National Construction Code (BCA) 2011 Initial Assessment Report

Eastlakes Town Centre Gardeners Road, Sydney, NSW, 2018

Prepared for: Crown & Prosha Joint Venture

Date: 5 July 2012

3 PLAN  
BLD1B - LEVEL 1 1:200

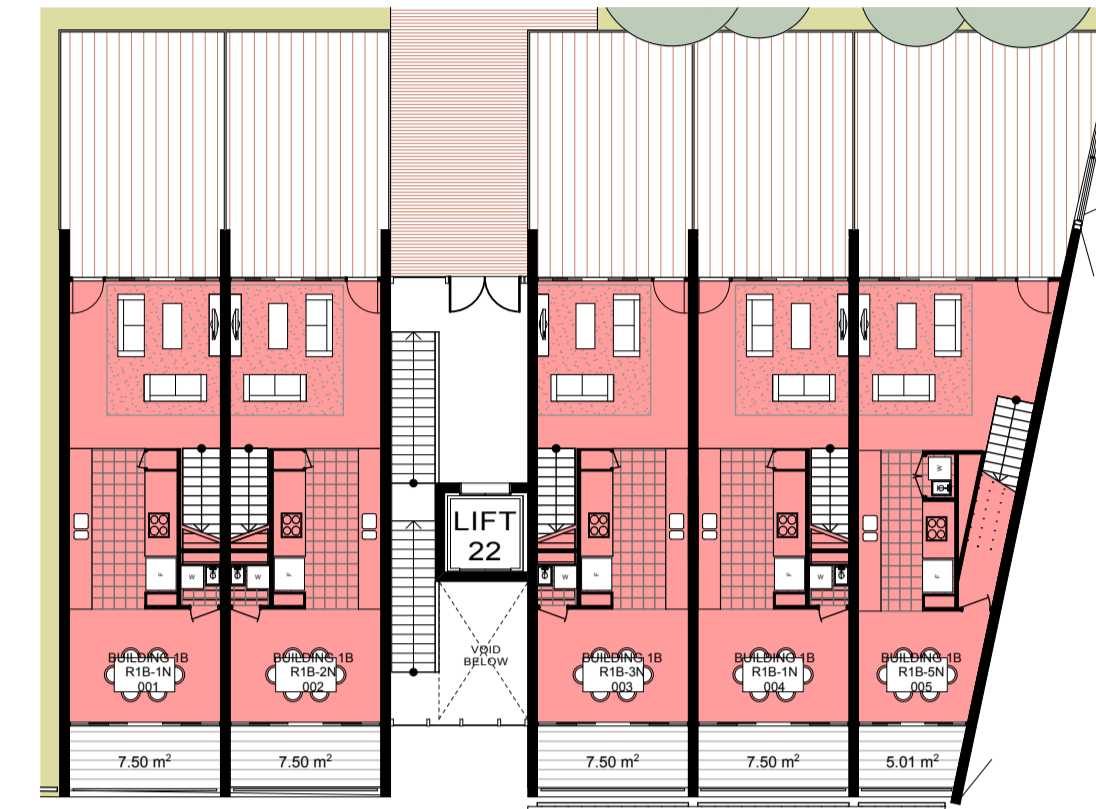
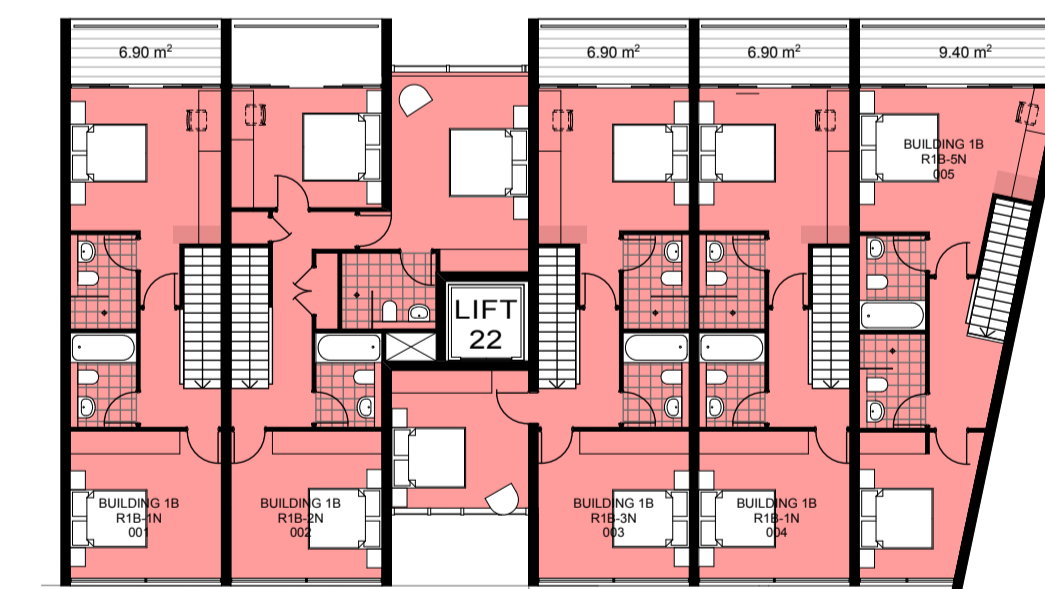
Five non-fire isolated fire stairs have been initially identified serving Buildings 1b & 5 and appear to comply with this clause.
